Our Ref: EN010092

Date: 24 June 2020

Application by Thurrock Power Ltd for an Order Granting Development Consent for the Thurrock Flexible Generation Plant

Advice following issue of decision to accept the application for examination

Thurrock Flexible Generation Plant Access, Rights of Way and Traffic Regulation Plans Sheet 3 of 5

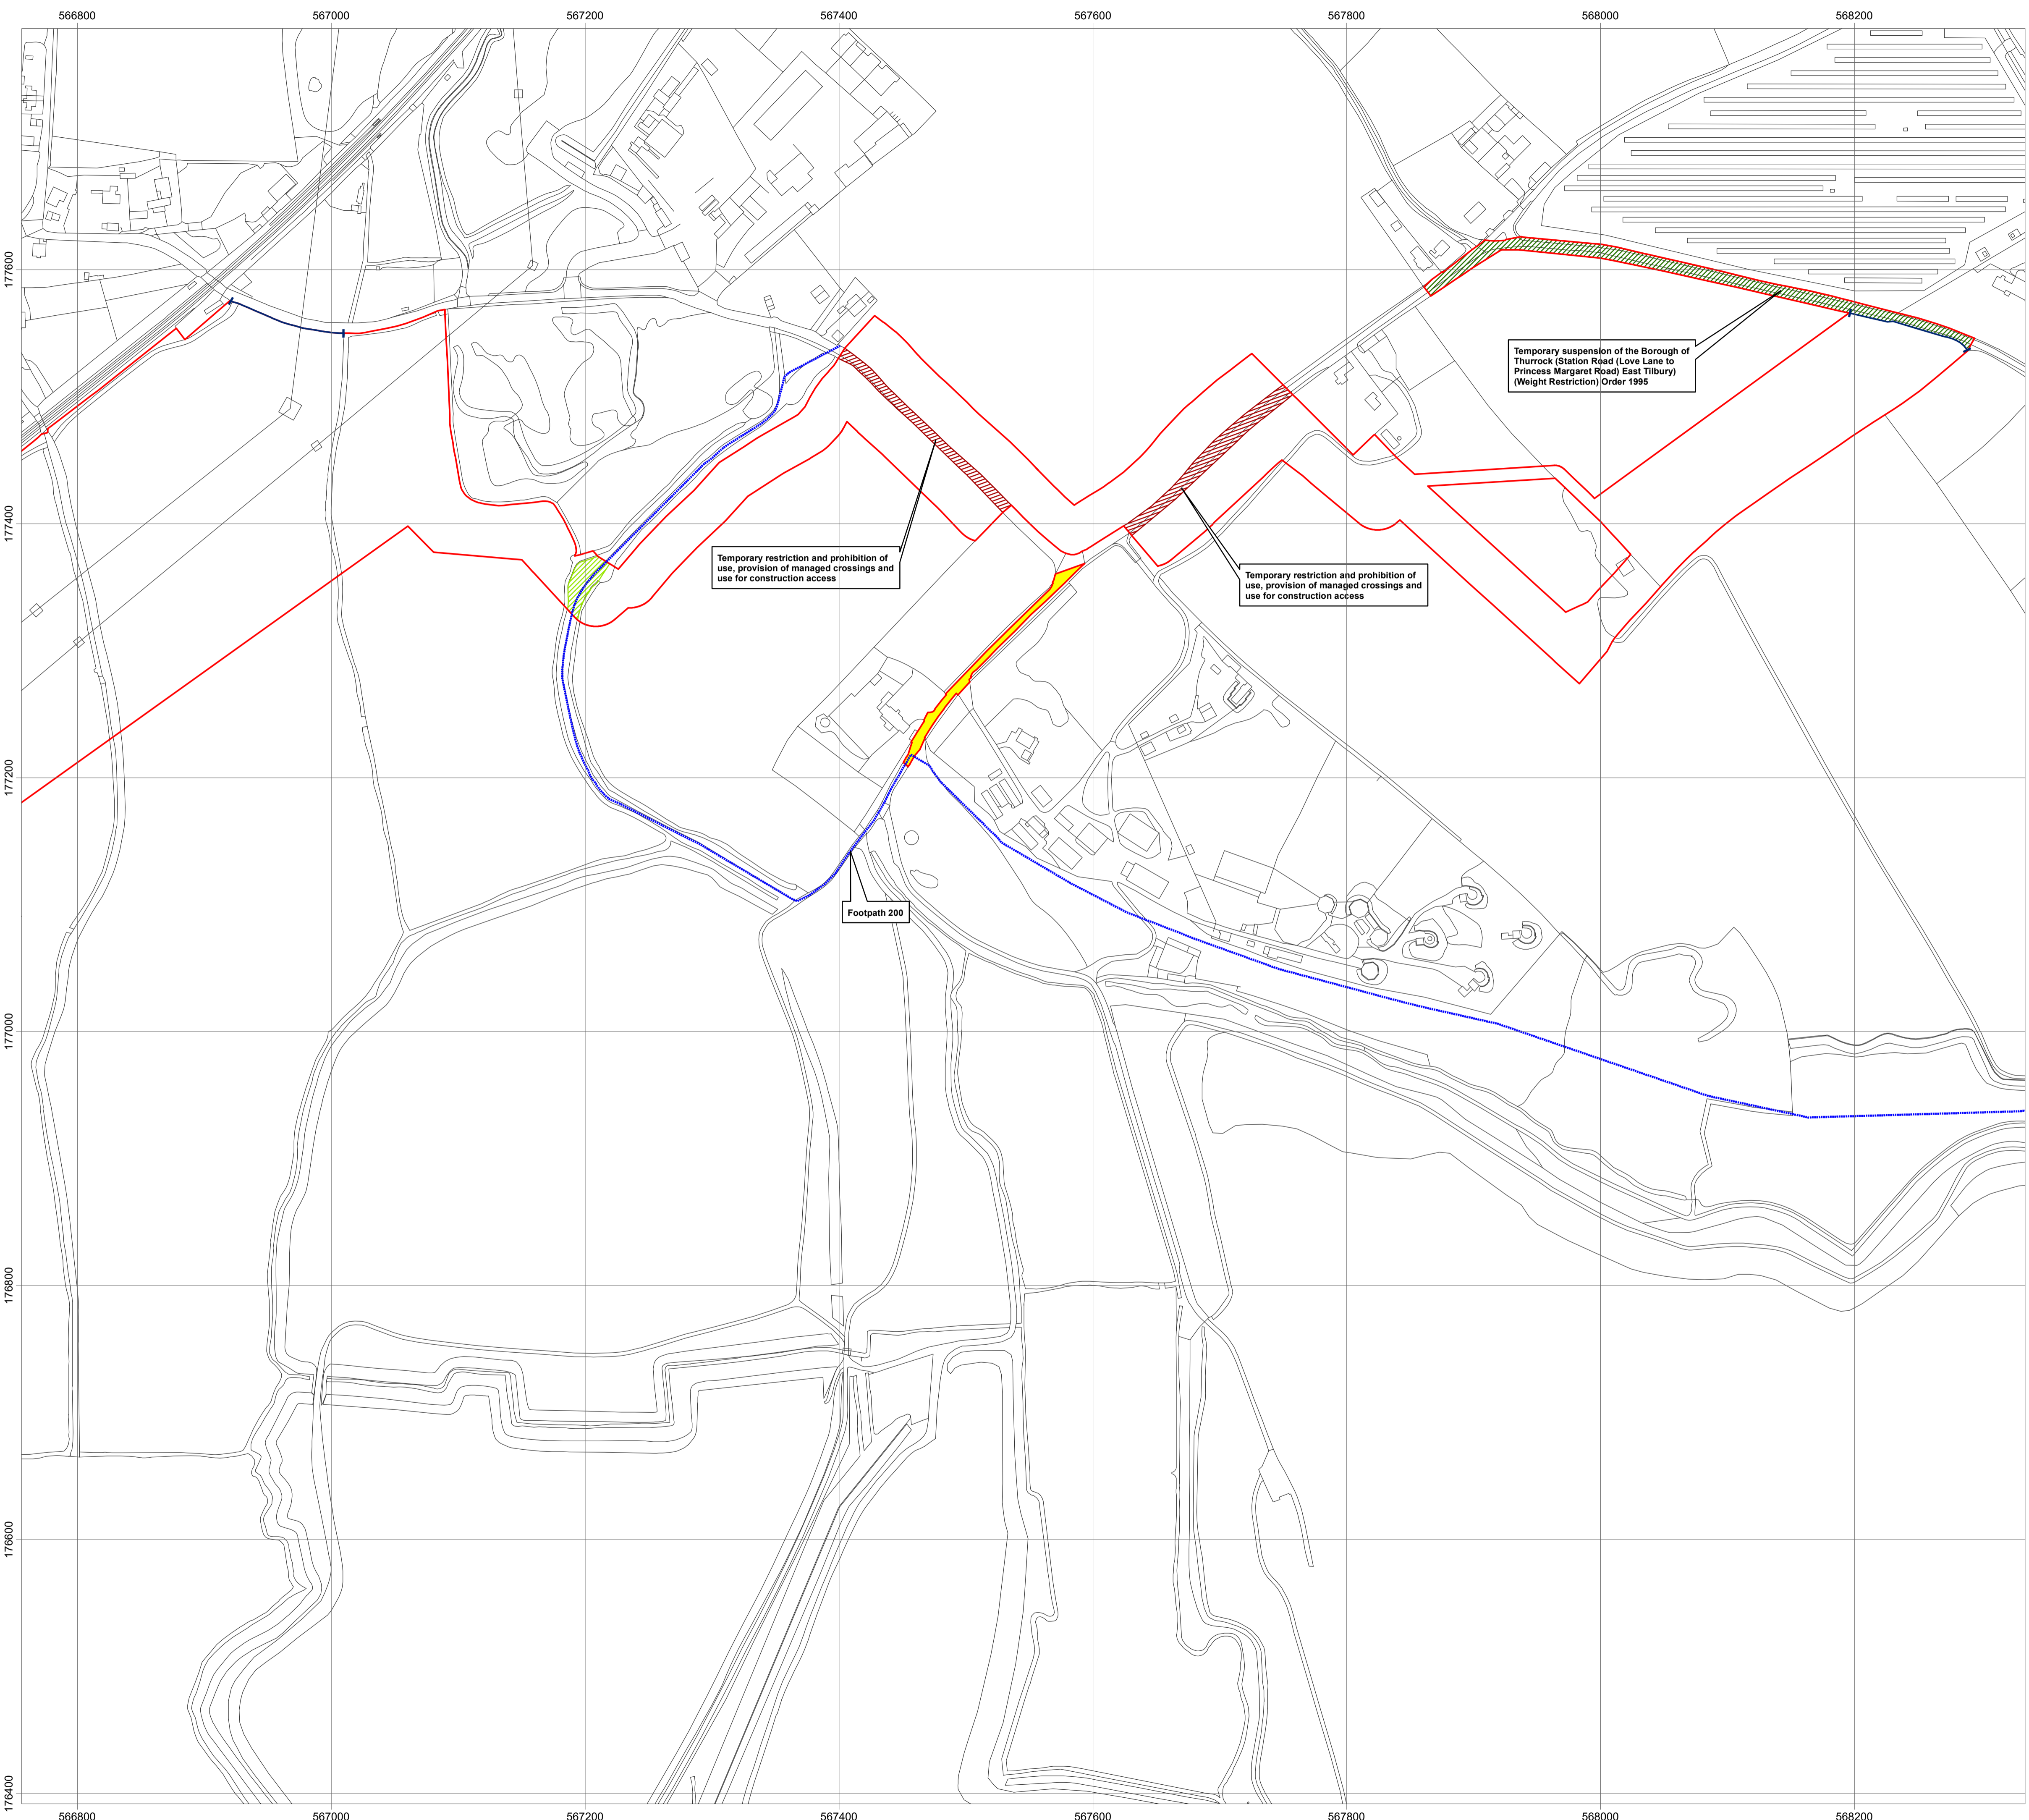
- There appears to be an inconsistency between the description on the plan and legend (sheet 3 of 5 of Doc A2.4) and Schedule 3 of the draft DCO. The plan refers to a temporary suspension of the weight restriction on Station Road (Love Lane to Princess Margaret Road). The draft DCO goes on to state in the column on "extent of suspension" that it will be 'suspended in its entirety'. It should be made clear in this column that the change relates only to the length between Love Lane and Princess Margaret Road.
- Schedule 4 of the draft DCO refers to solid dark green colouring on sheet 3 of Doc A2.4 to show the temporary suspension of the weight restriction on Station Road (Love Lane to Princess Margaret Road). However, on the plan dark green hatching is used.
